**Mount Pleasant Coal Project (DA 92/97 MOD 3)
Request for Additional Information**

I am writing to seek additional information to inform the Department's continued assessment of the third modification application for the Mount Pleasant Coal Project (DA 92/97 MOD 3).

MACHEnergy
 MOUNT PLEASANT OPERATION
 Noise Monitoring Sites,
 Revised Noise Assessment Groups
 and Existing Mt Arthur Receiver Zones

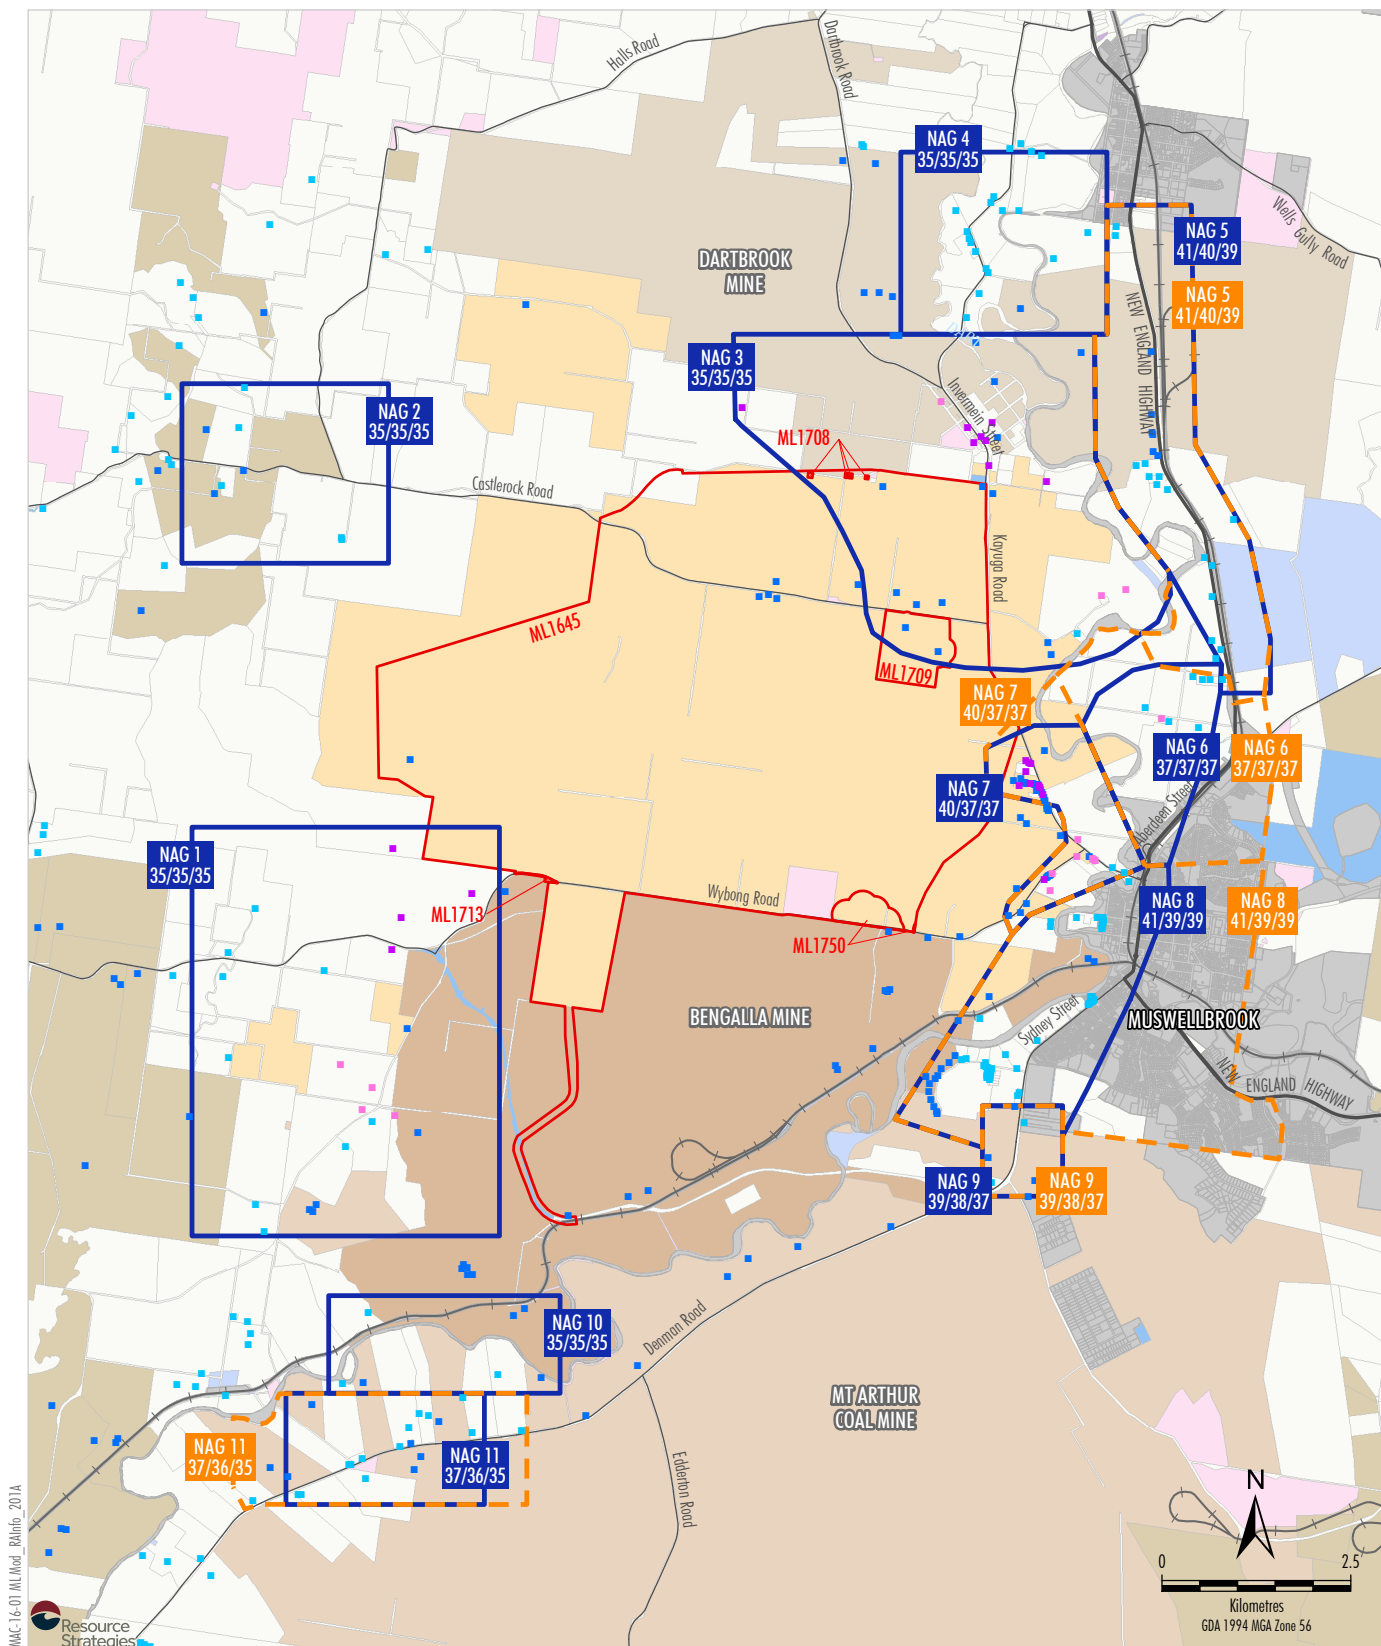
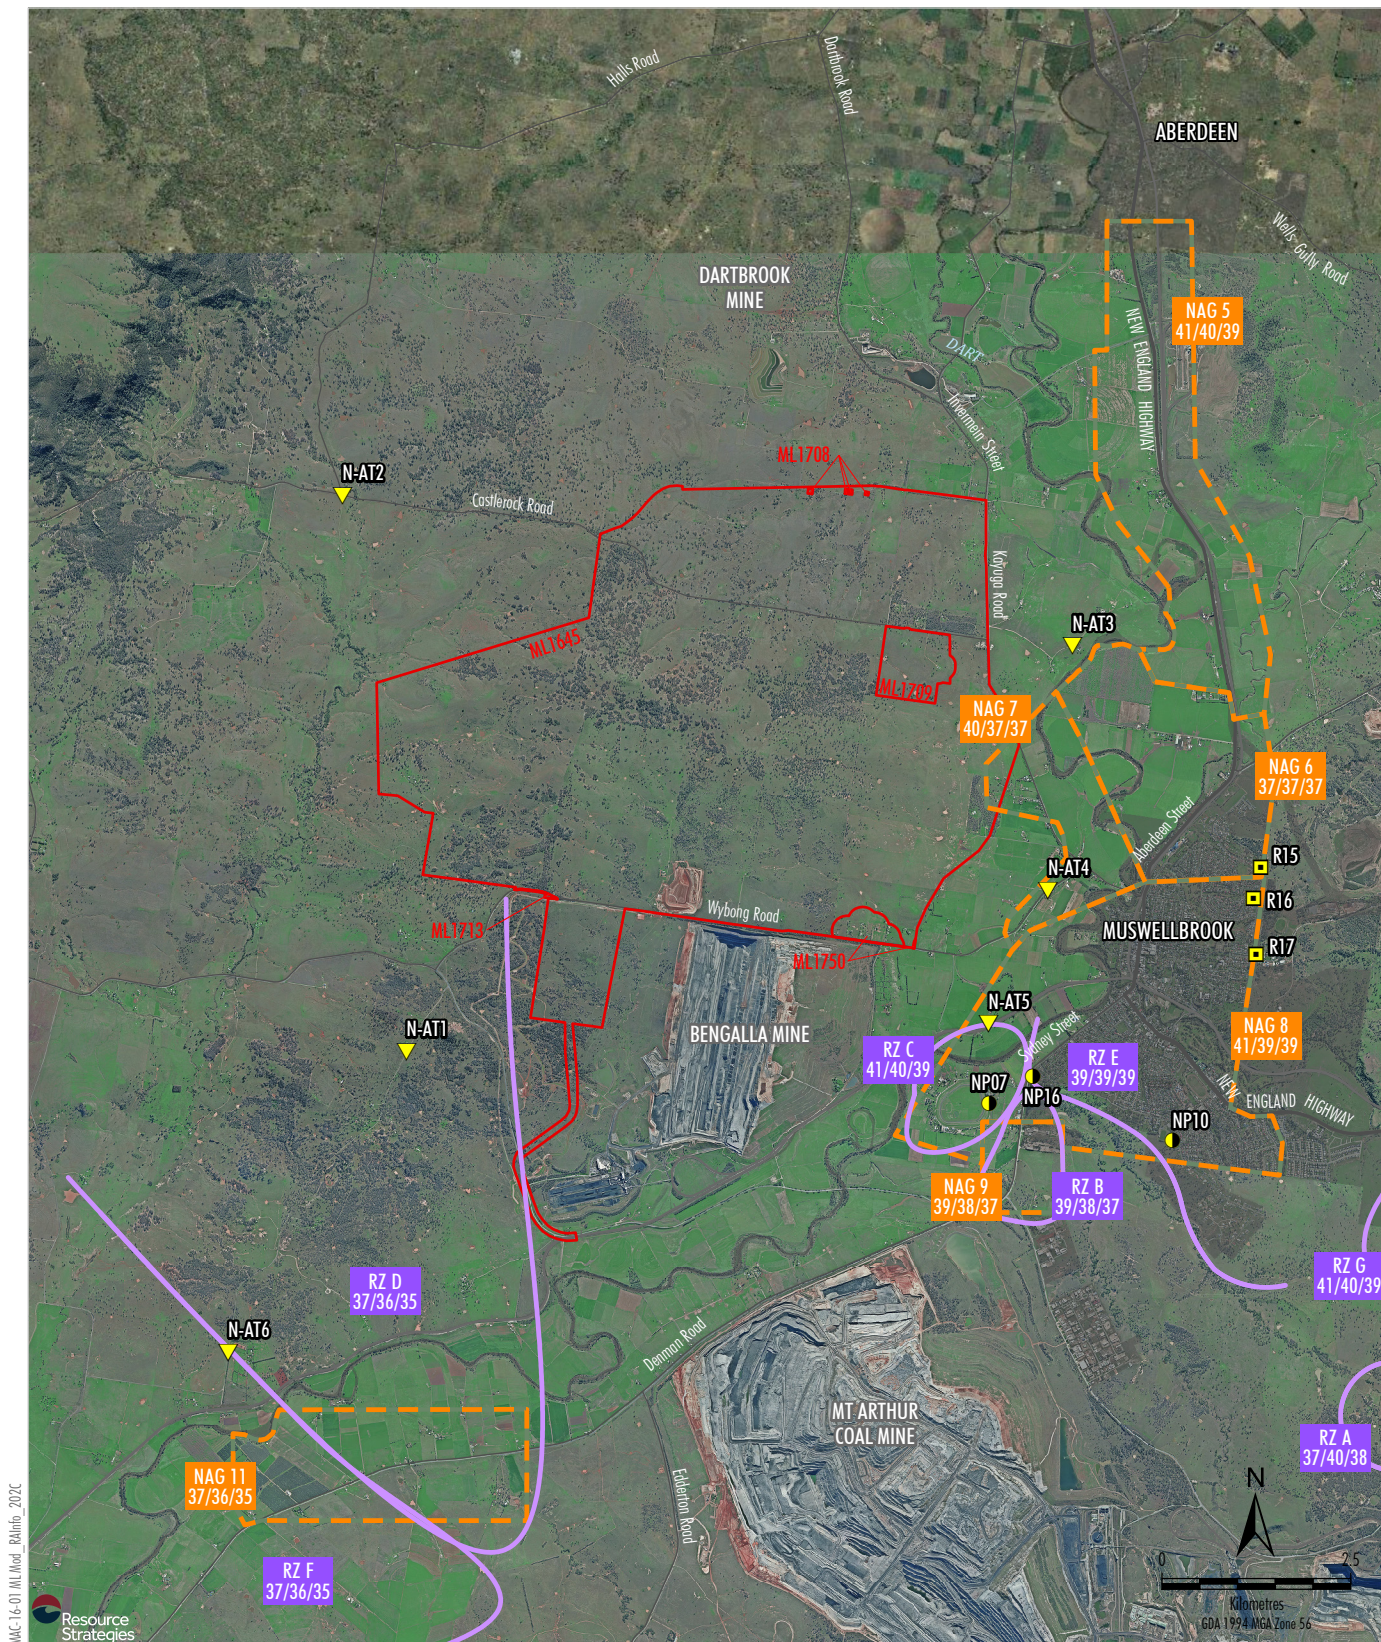
The Environmental Assessment (EA) identifies that the delineation of noise assessment groups (NAGs) has been amended relative to the existing approved project. The Department does not consider that sufficient justification has been provided for the proposed changes in NAGs, which would increase the existing noise criteria applicable to a substantial number of properties. Further, the Department is not yet convinced that all of the proposed extensions to existing NAG boundaries are reflective of background levels in these locations.

I also note that the proposed NAG boundaries appear to cover a broad range of predicted noise levels, for example NAG 8 includes predicted impacts ranging between 45 dB in the west to less than 35 dB in the east. Given this range of predicted impacts, the Department is unlikely to recommend the application of uniform noise criteria for all residents within these areas, especially in areas such as east Muswellbrook where the project is predicted to meet lower noise limits. I would therefore request that further consideration is given to the refinement and differentiation of receivers within NAGs (especially NAGs 6, 7 and 8).

Further, the Department is concerned that the reliance on previous studies and justification provided in relation to changes proposed in the EA do not address the contemporary noise assessment requirements requested in the Department's letter of 2 June 2016.

Figure 6 Water Management System Schematic

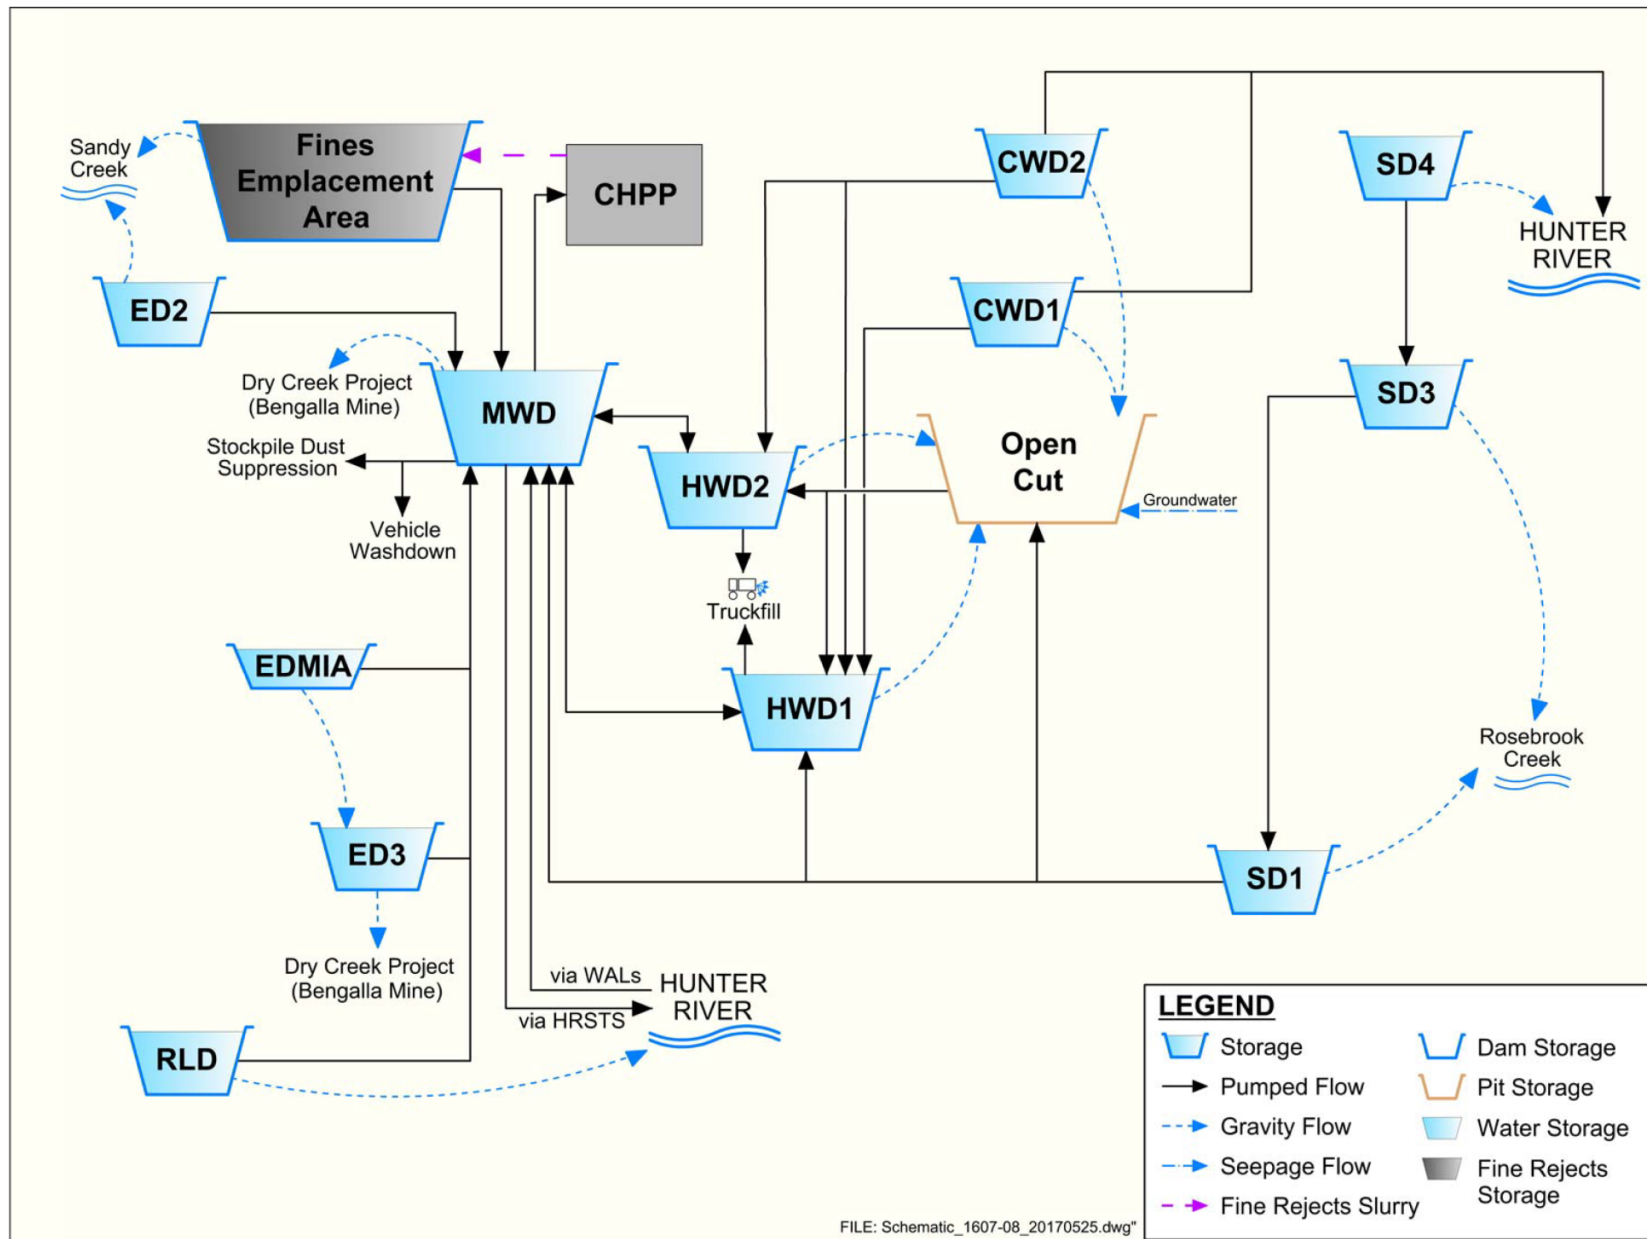
It would appear from the layout of the water management system that dams MWD and ED3 would be located on the site's boundary with Bengalla Mine. The RTS identifies that, while no spills were simulated for the Fines Emplacement Area and MWD, any rainfall in excess of the design criteria for the Mine Water Dam would flow to the Dry Creek Diversion Project. Having considered the current setting of the surface water environment, the Department notes that, if there is sufficient excess water to spill from the MWD, this rainfall event coupled with the additional MWD water could also exceed the capacity of structures in place for the Dry Creek Diversion and pose a risk of spilling into areas of land owned by the adjacent Bengalla Mine.

In the unlikely event that the dams overtop and flow to the south, this could result in potential pollution and safety risks, as well as operational disruptions to Bengalla Mine. An alternative option that has been applied at other mine sites throughout the Hunter Valley would involve

spillway designs for MWD and ED3 that direct water towards the east and flood the Mount Pleasant open cut pit instead of travelling offsite to the south. The Department understands that MACH Energy is continuing to negotiate with Bengalla over potential surface water interactions and management systems and requests that you provide an update on the appropriate management and/or retention of water onsite in the unlikely event that these dams fill beyond capacity.

It is unclear how the water discharges from the various water storage facilities, such as dams and fines emplacement areas, will be treated before discharge to the receiving environment. For example, it is proposed that the Fines Emplacement Area and ED2 discharge to Sandy Creek, SD4 to the Hunter River and SD1 and SD3 to Rosebrook Creek (Figure 6 in Appendix E of the EA). These water storage facilities could contain a range of pollutants such as coal fines, oil and grease and suspended particulates. While a preliminary response to these matters has been provided in the RTS, the EPA and the Department have residual concerns with the management of these potential impacts. Please provide more detail regarding the treatment and licensing of various discharges to meet suitable water quality standards for receiving waters.
